From: Ancient Monuments Society [ancientmonumentsociety@btconnect.com]
Sent: 24 August 2012 18:34
To: Jane Tucker
Subject: Re: Consultation on planning application 3/2012/0709 St Johns Church, Shire Lane, Hurst Green
 Thankyou for your consultation.

Please can we have your comments on the above planning application? It is for the creation of accessible and sustainable composting toilet facility externally to the rear (North) of the church. Adaptation of lower section of existing window to form level access to accessible toilet from inside the church with clear separation between door head and window sill provided by the natural stone infil. Associated creation of level approach to the perimeter of the church by improvements made to existing North and West facing paths. I have attached the formal consultation but there are too many plans and documents with the application to attach to an email, so here is a link to view them on our website <http://www.ribblevalley.gov.uk/planningApplication?appNumber=3%2F2012%2F0709&submit=Go>

Drawing Title
Proposed plan, elevations and section.

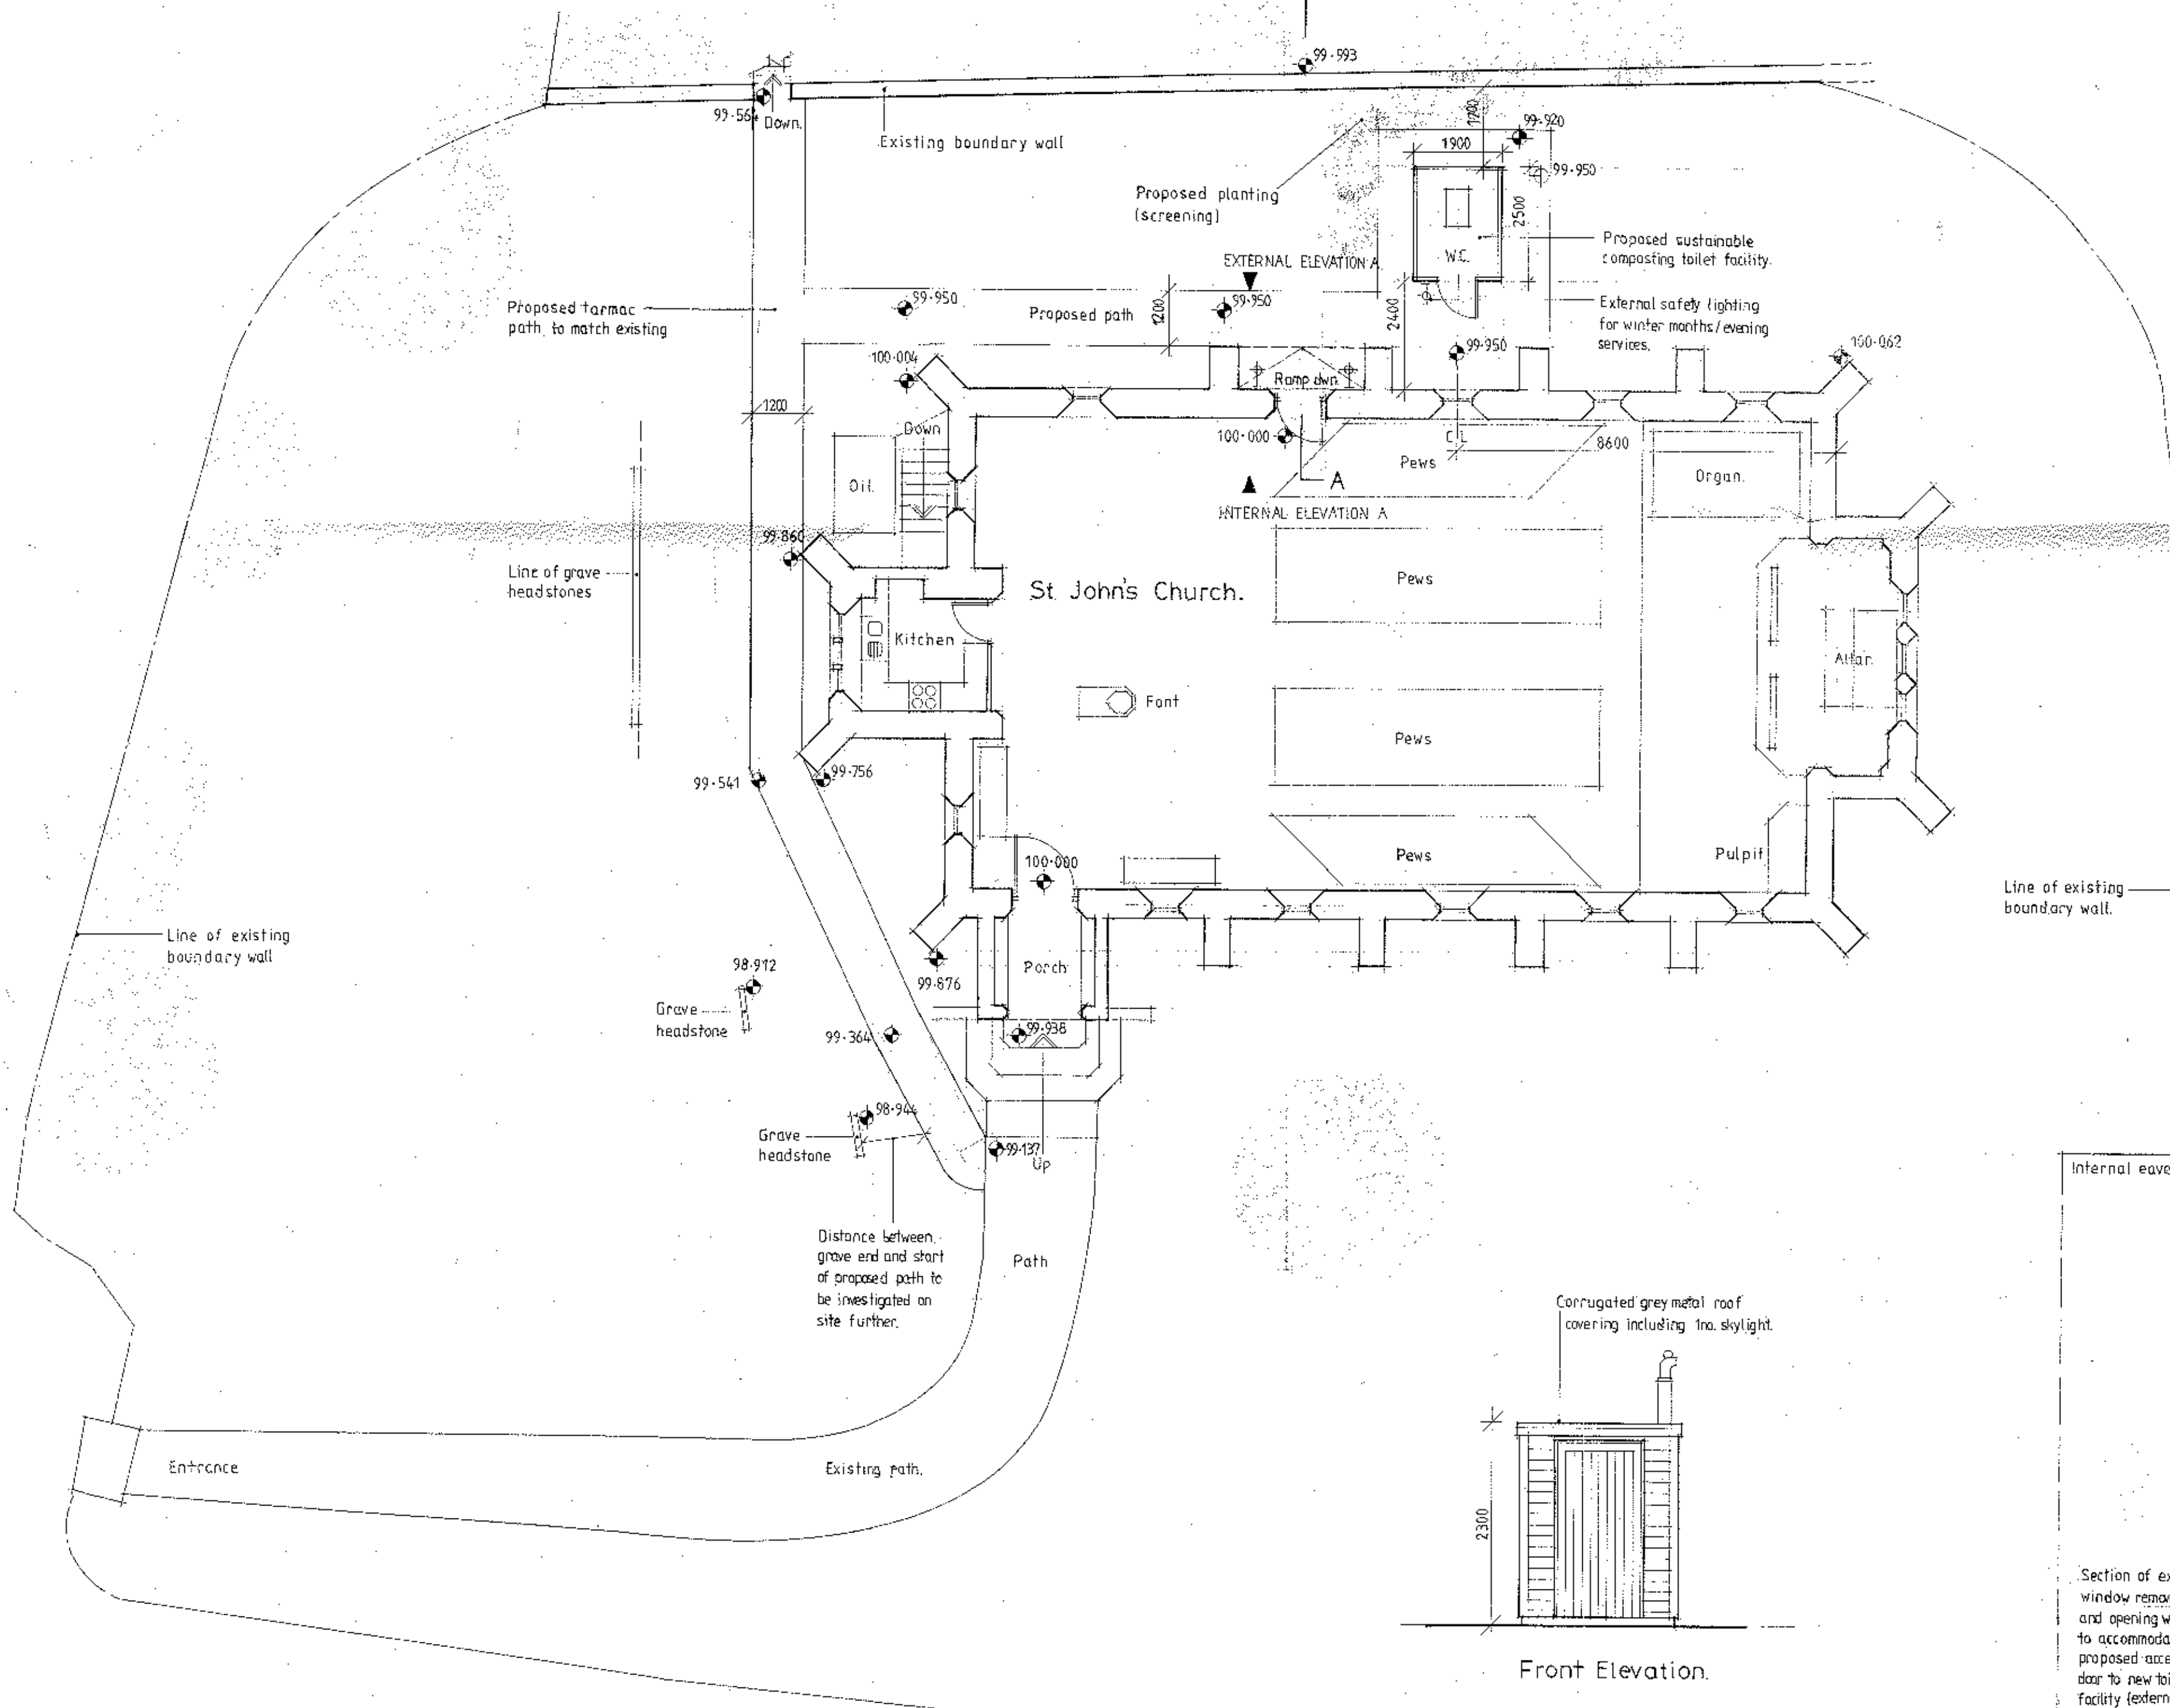
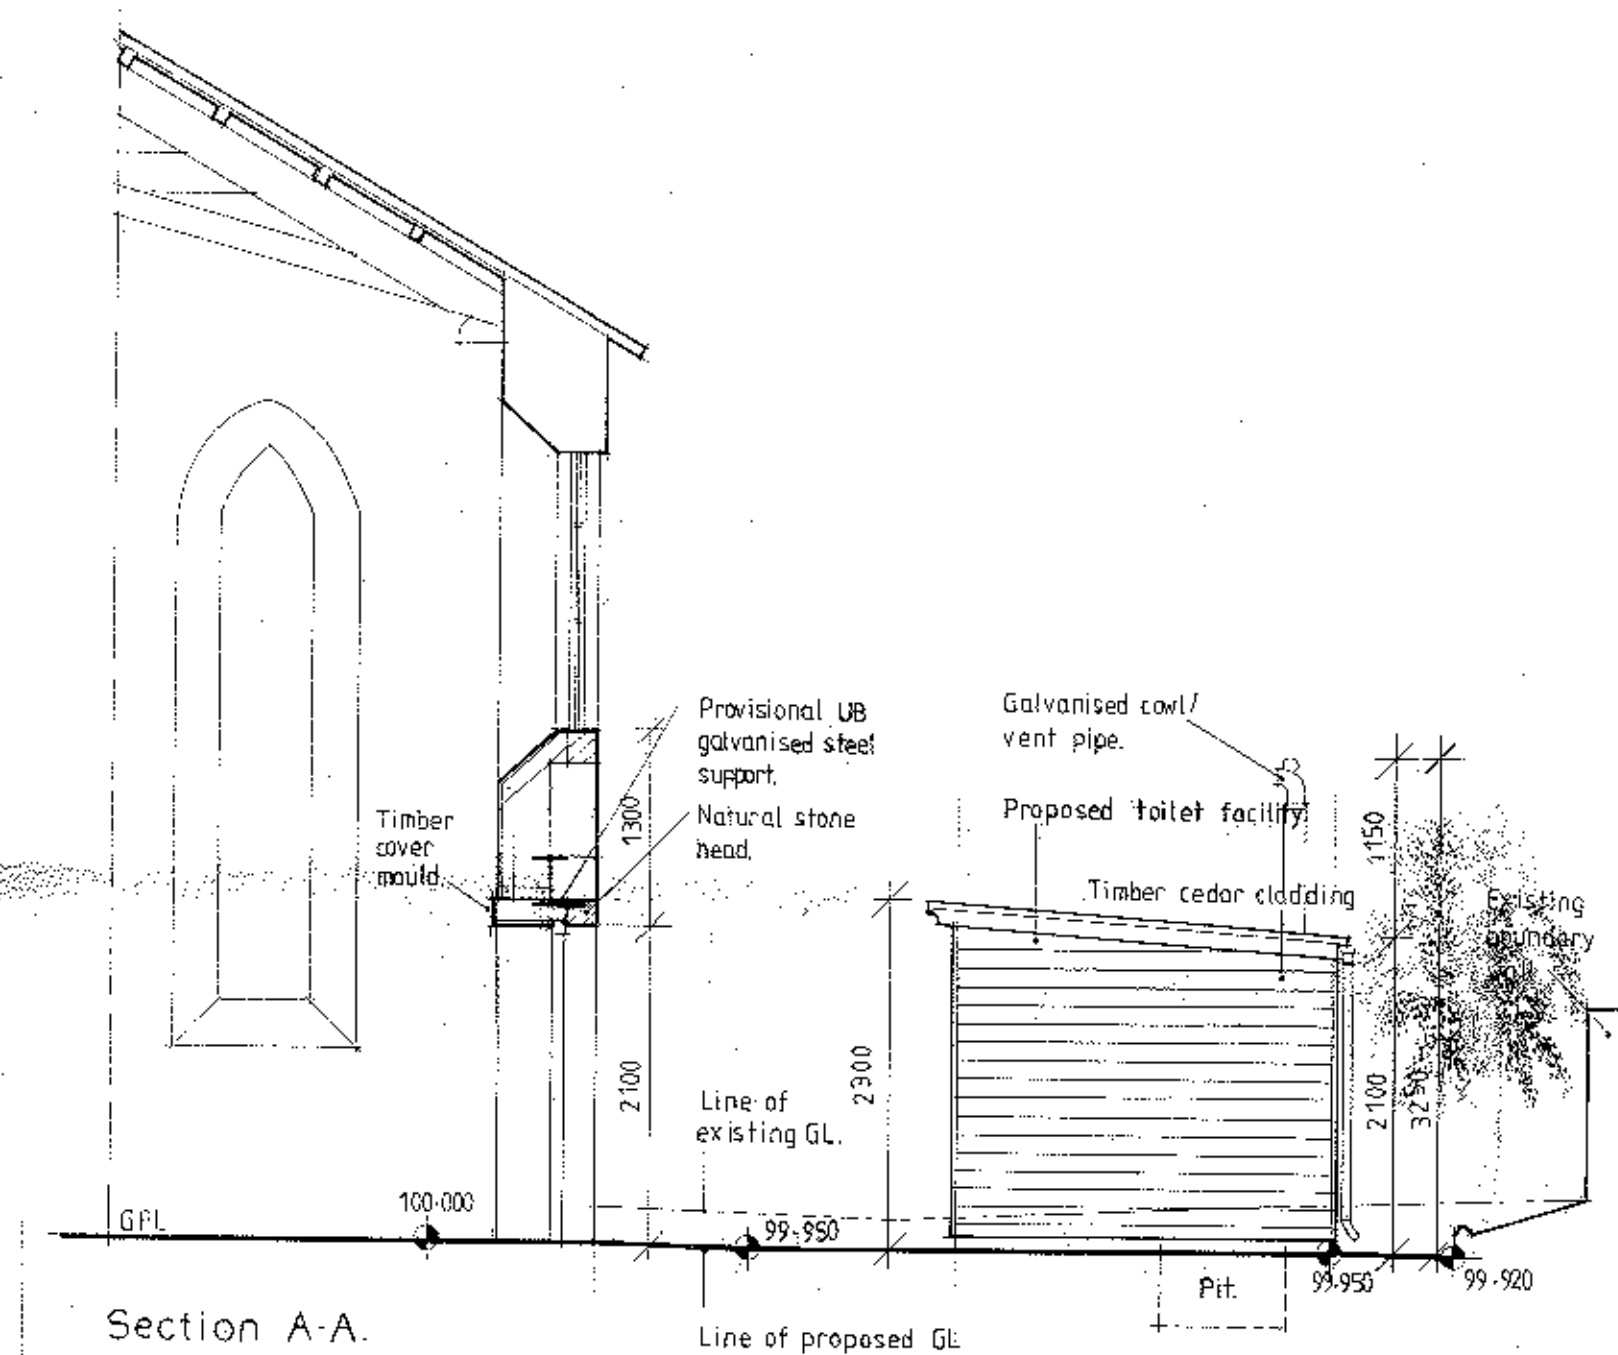
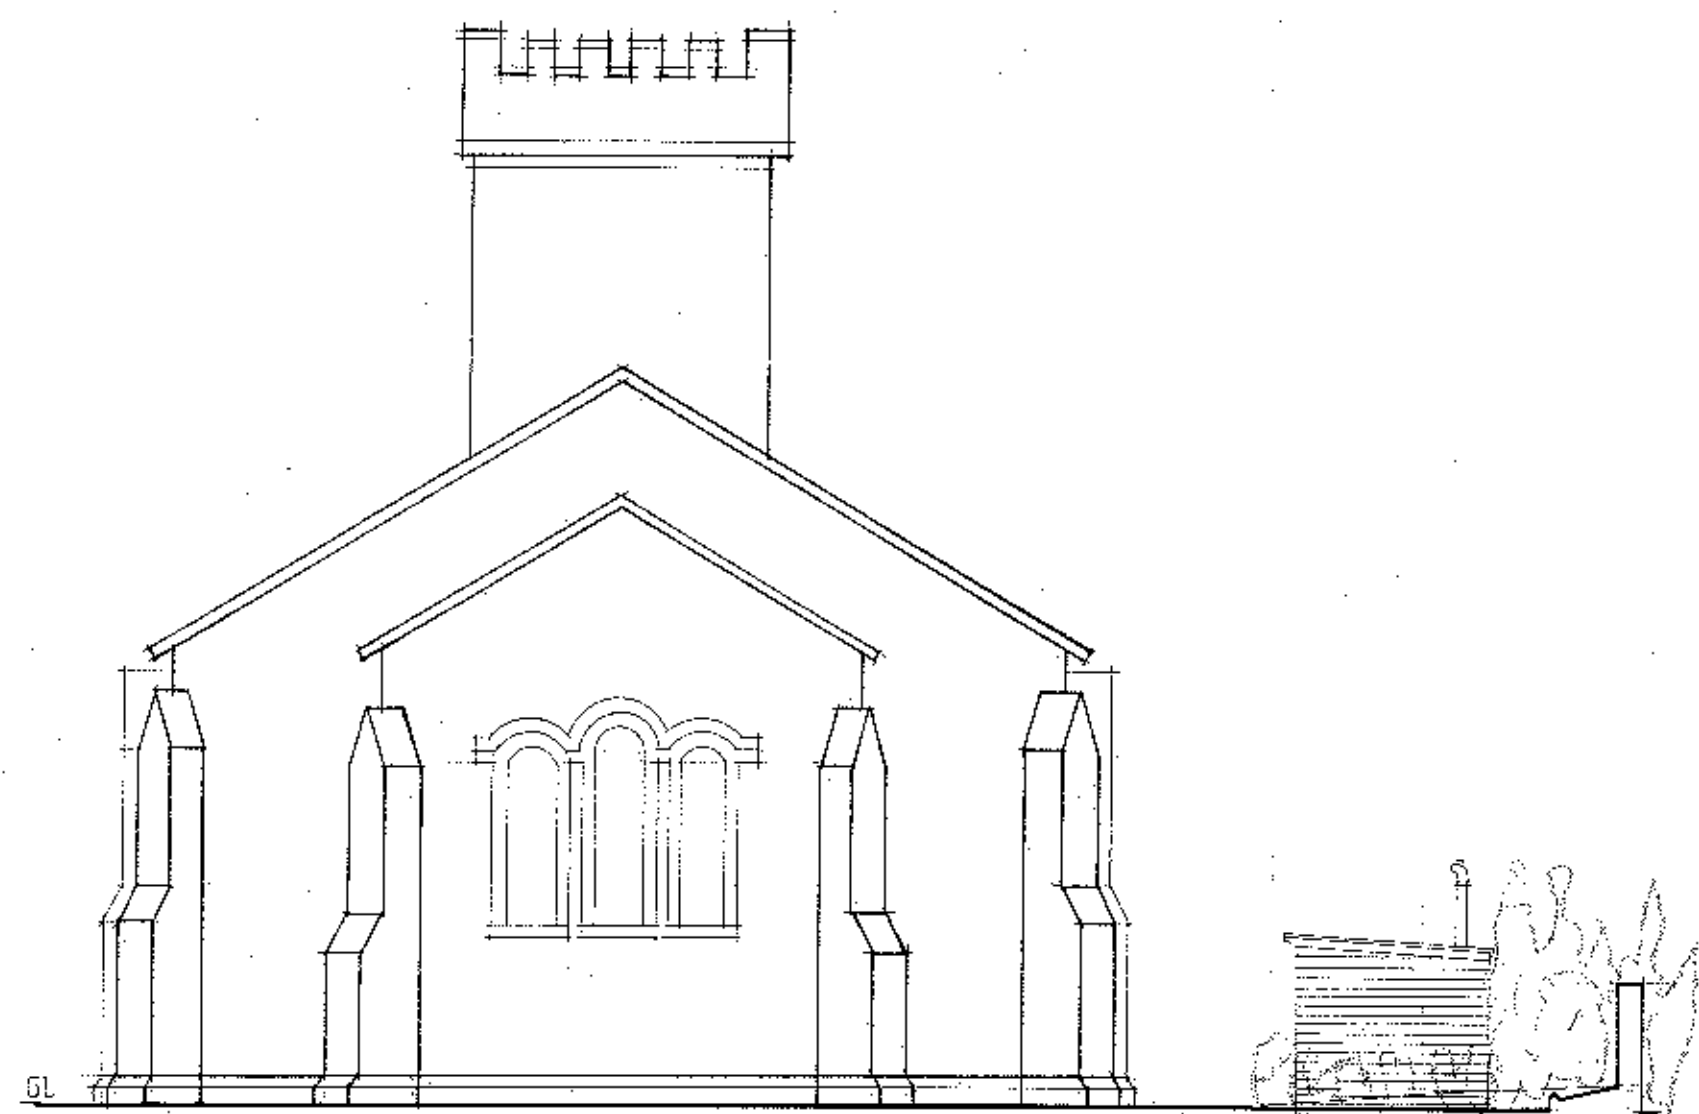
As the new facility is diminutive compared with the dominance of the church, the adverse affect on setting is clear but minimal. The analogy perhaps is with the many lawn mower sheds in a country churchyard.

Even so, it would surely be less intrusive and more user-friendly if the loo were provided discreetly within the interior. It is true that the openness of the interior and the lack of the sort of spaces which have been used on similar occasions - a north porch, a vestry or a tower base (already taken by the kitchen) - creates problems but loos disguised, for example, as vestment cupboards at the west end do work in visual terms.
